**Subject:** RE: 82 Mersey Street Longridge

**From:** Jason Middle [k]  
**Sent:** 18 March 202  
**To:** George Devers <  
**Subject:** RE: 82 Mersey Street Longridge

Drawing file: planx_downloads / 21_0322_Site_Plan.pdf

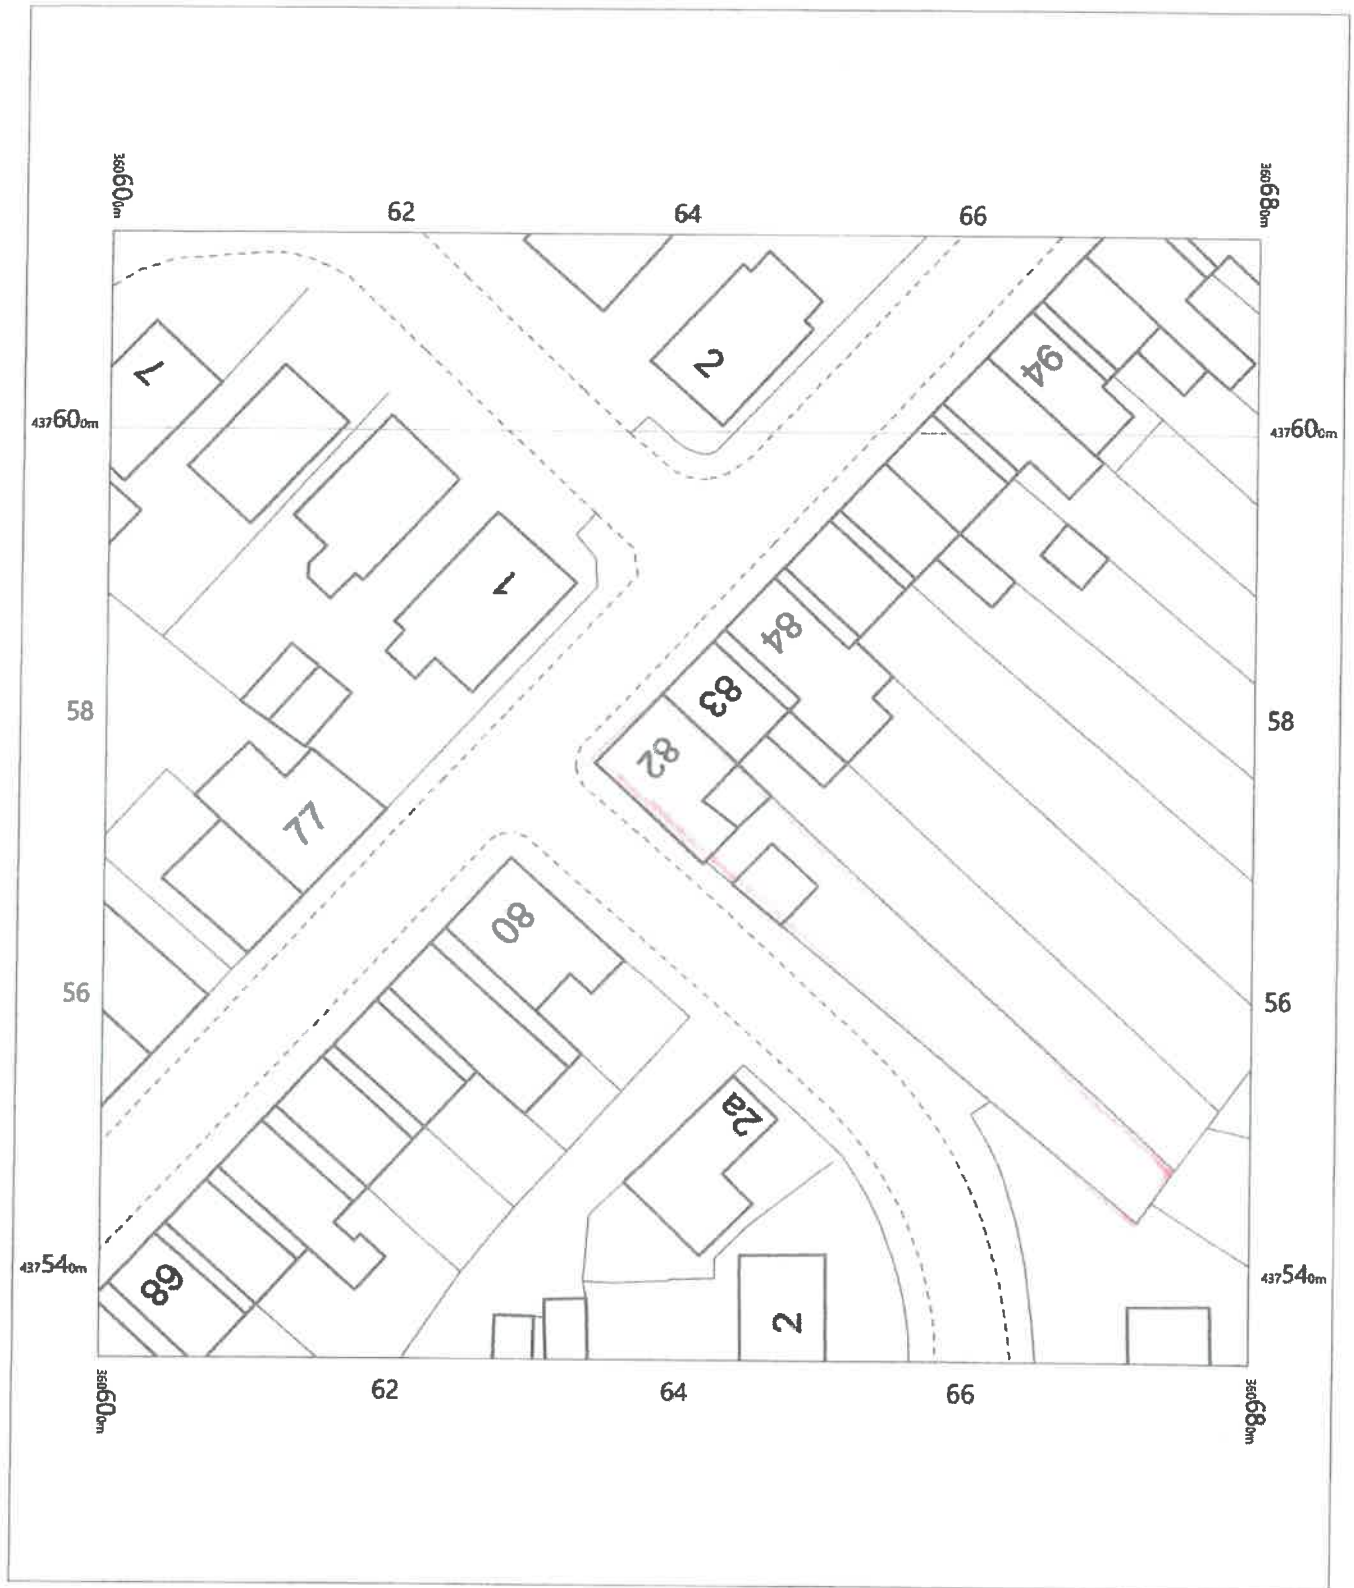
- Difficult to assess correctly as its not complete
- it's slightly over PD if it's 2.6 metres high and within 2 metres of the boundary so it would be advisable to get it to 2.5 metres high
- Need to make sure its not be capable of self-contained living accommodation. A bar and toilet would probably be ok but if it is more of an annexe then it needs permission.
- The only way to formally confirm if its Permitted Development is via a certificate of lawfulness so you could invite an application - [https://www.ribblevalley.gov.uk/downloads/download/7166/lawful\\_development\\_certificate](https://www.ribblevalley.gov.uk/downloads/download/7166/lawful_development_certificate)

Hope this makes sense? Basically you could do with reducing the height slightly to ensure PD compliance and a certificate of lawfulness application would legitimize what you are doing.
